PORTLAND MAINE

Project Name: **409 Cumberland Apartments** Project ID: 2013-148
Address: 409 Cumberland Avenue CBL: 036 H018001, H019001
Applicant: Avesta Housing, Avesta 409 Cumberland, LP
Planner: Caitlin Cameron

PLANNING BOARD REPORT PORTLAND, MAINE

409 Cumberland Apartments
409 Cumberland Avenue
Level III Site Plan/Subdivision
Project ID #: 2013-148
Avesta Housing, Applicant

**MECHANIC STREET**

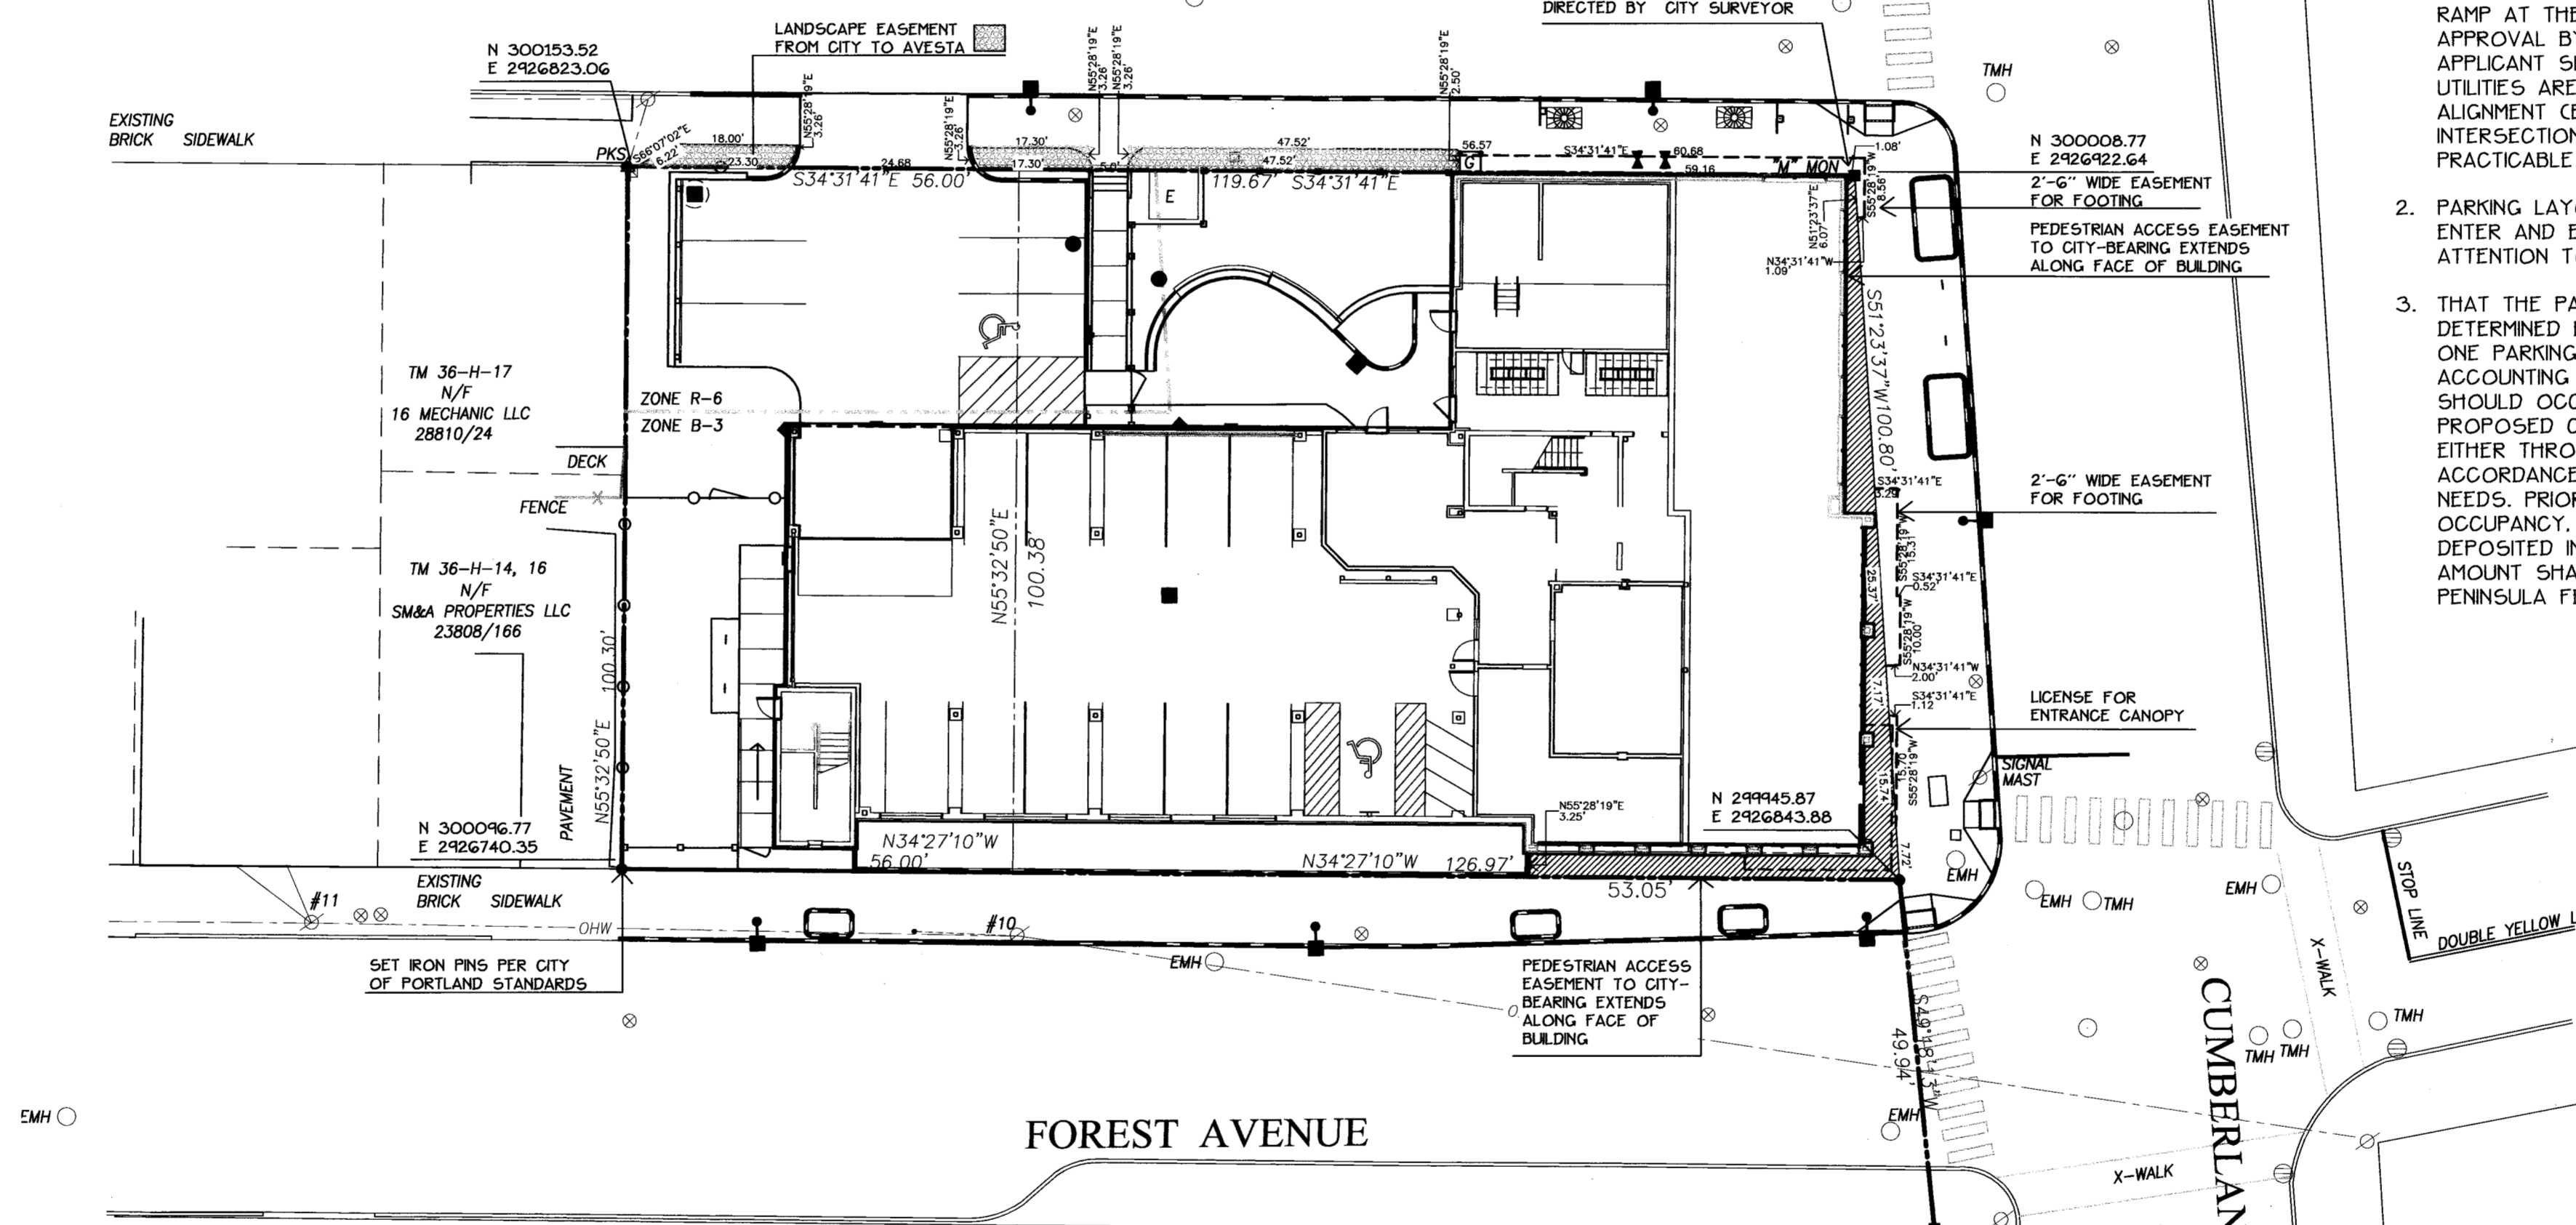
1. The applicant shall submit plans for a revised sidewalk ramp at the Mechanic Street intersection for review and approval by the Department of Public Services. The applicant shall provide specific information on what utilities are impacted for perpendicular crosswalk alignment (both crosswalks) at the Forest Avenue intersection for review by the City in assessing the most practicable option.

2. Parking layout should be revised such that vehicles can enter and exit the site front first with particular attention to the ADA space inside the garage.
